Re Planning Application P/74/13 - 2 Lagoon Road, Pagham

I wish to object to the above Planning Application.

REAR

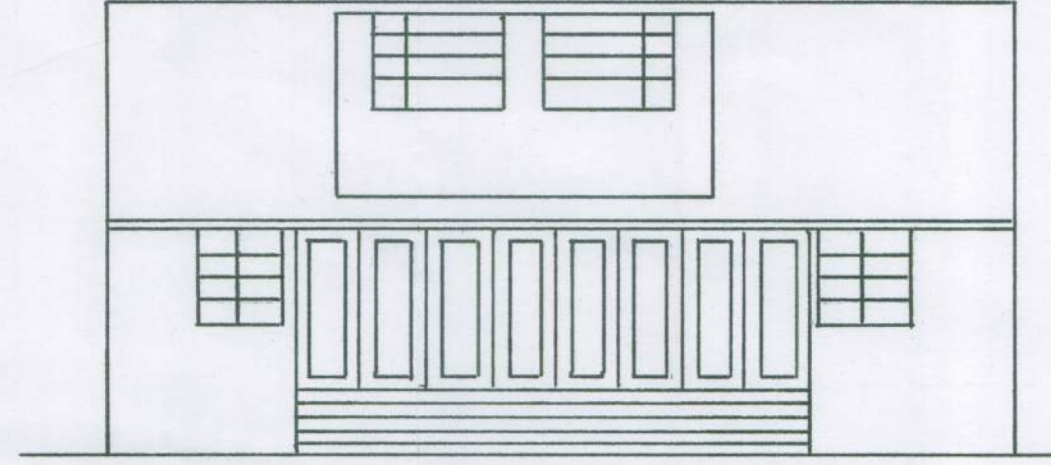
There is no existing Dormer Window to the rear of this property, only one to the front. Building a new Rear Dormer fronting Well Road, would infringe on the privacy of Nos. 2b & 2c Well Road.

Roof Lights in the adjacent property, No.4 Lagoon Road were rejected by the Planning Dept. This new Dormer would obtrude even more.

"The character of the Pagham Beach Estate derives from the distinctive scale and height of the residential buildings, being of single storey with no accommodation in the roof". This original property is a 'one off' but I feel that it still shouldn't be allowed to flout the ethos of the Estate by constructing another Dormer in the roof.

REAR WALL & GARAGE

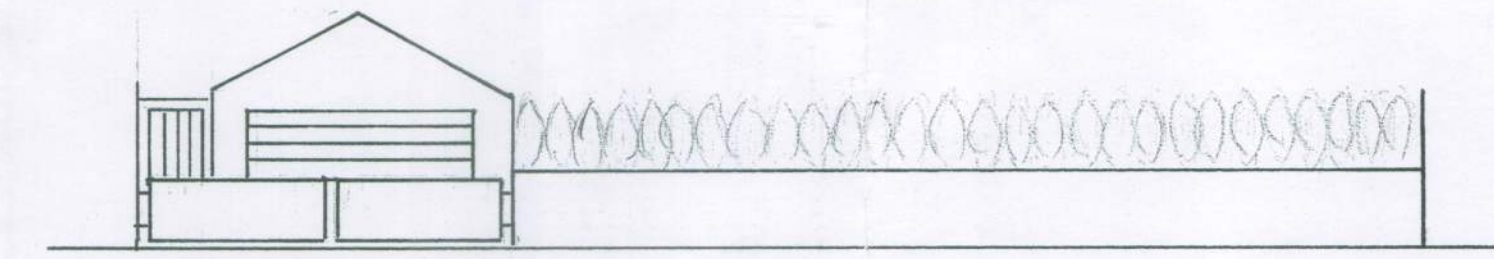
The height and proposed materials to be used doesn't appear to have been mentioned.

I have objected previously to the fence and will do so again to this wall which appears to follow the same line. The fence is erected on a parcel of land taken from the roadside which doesn't belong to the applicant. I am disabled and this fence adjacent to the road restricts the access to my drive. A wall replacement would cause the same restriction on my access.

The proposed wall is to be built on land immediately adjoining Well Road which is owned by Pagham Beach Holdings Ltd and is subject to an ongoing legal dispute.

SITE PLAN 1:200

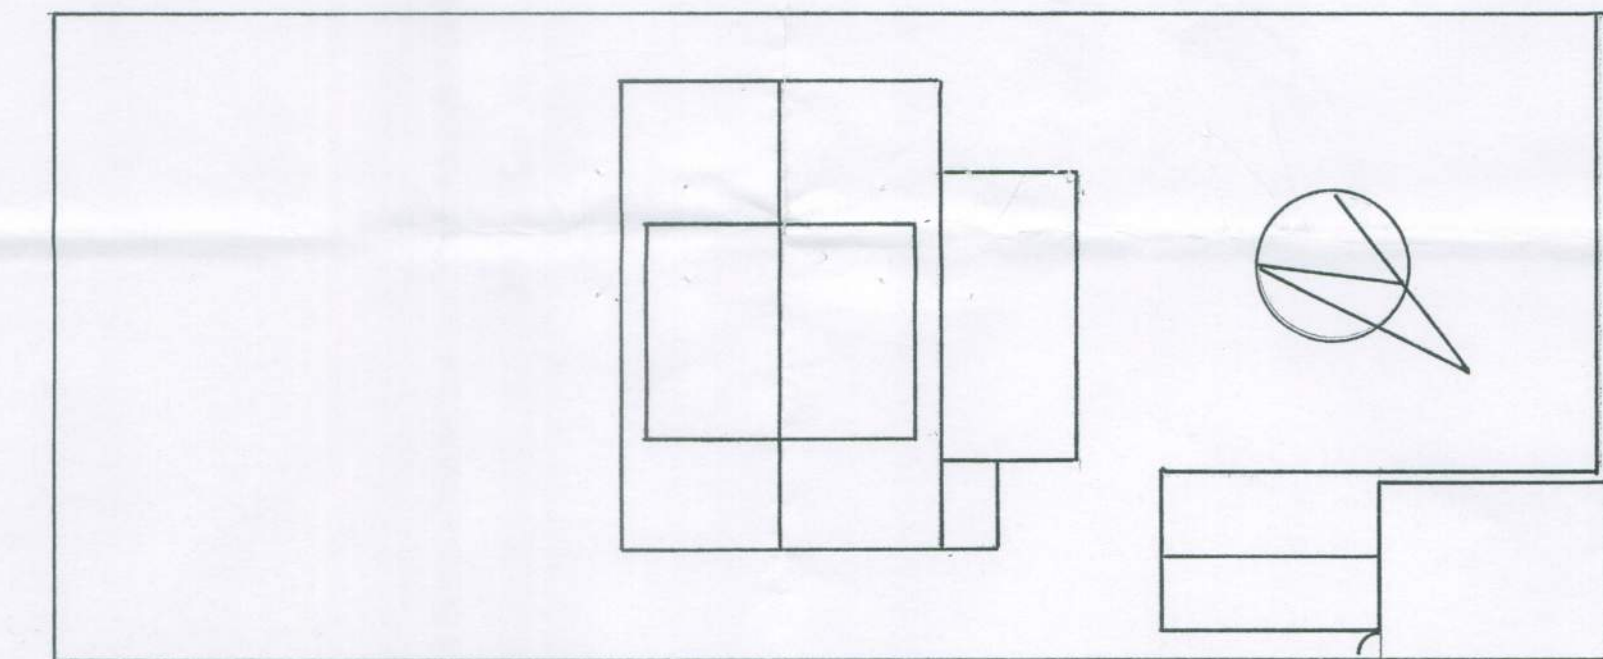
I enclose for your perusal an area plan submitted by 4 Lagoon Road in his Planning Application, as you can see, the boundary of No.2 differs from the one submitted by this applicant. No.2 has now moved his unregistered boundary to the edge of Well Road.
